**Consultation Response from KC,
Trees**

2025/91126 36, Oxford Road, Dewsbury, WF13 4LL

**Erection of two detached dwellings and detached single garage with associated external works
(within a Conservation Area)**

Date Responded: 10/12/2025

Appendix 2: Plans

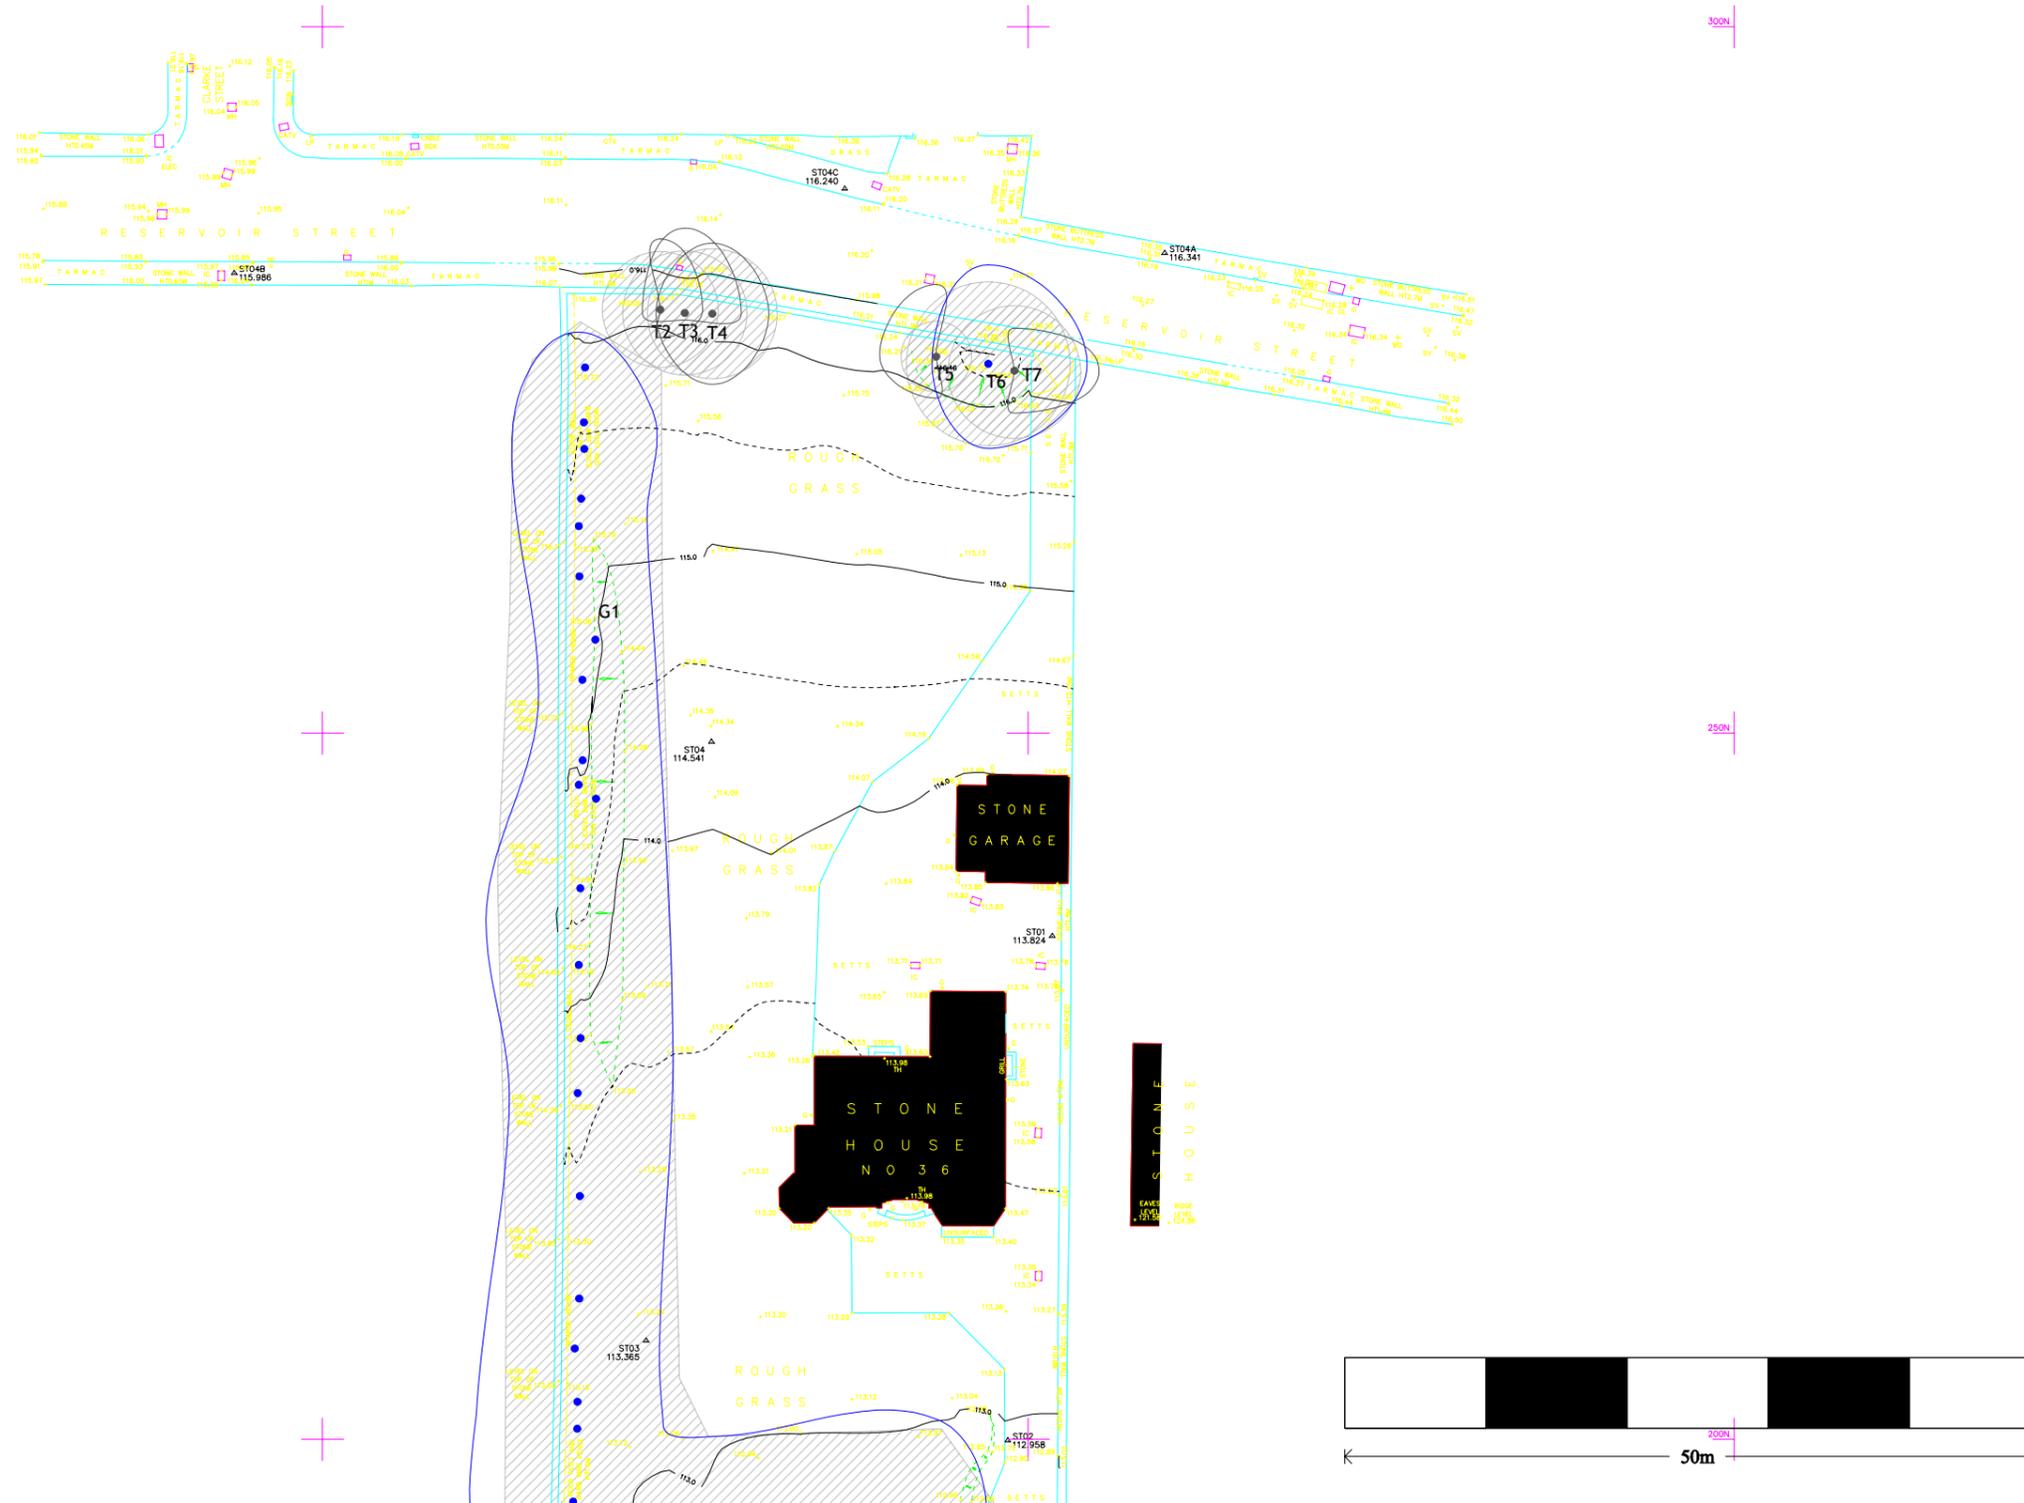
It is proposed to remove protected horse chestnut, **T7** to facilitate the widening of the driveway, off Reservoir Street. There is an existing driveway in this location, which runs along the Eastern boundary. Therefore, it is questionable as to why this existing driveway could not be retained, in its current format, avoiding the need to remove the tree.

Additionally, the new hard standing proposed for the driveway of Eastern plot extends excessively within the RPA of retained, early mature sycamore **T6**. New hard surfacing must only be sited within the RPAs of retained trees where it is unavoidable, as construction within the RPA should accord to the principle that the tree and soil structure take priority and the most reliable way to ensure this is to preserve the RPA completely undisturbed. In this case, the extent of the proposed new hard surfacing would jeopardise the health of this valuable, protected tree.

Buildings and other structures should be sited allowing adequate space for a tree's natural development, with due consideration given to its predicted height and canopy spread. This is to ensure that the protected trees are not threatened by future pressure for removal. Protected trees within **G1** are threatened by the proximity of the proposed garage, which is sited within the RPA.

KC trees cannot support the current proposal as it would significantly impact TPO trees prominently visible along Reservoir Street, as well as protected trees along the Western boundary. There is an objection from an arboricultural perspective. The proposal conflicts with adopted Kirklees local plan policy 33 and 24 (i):
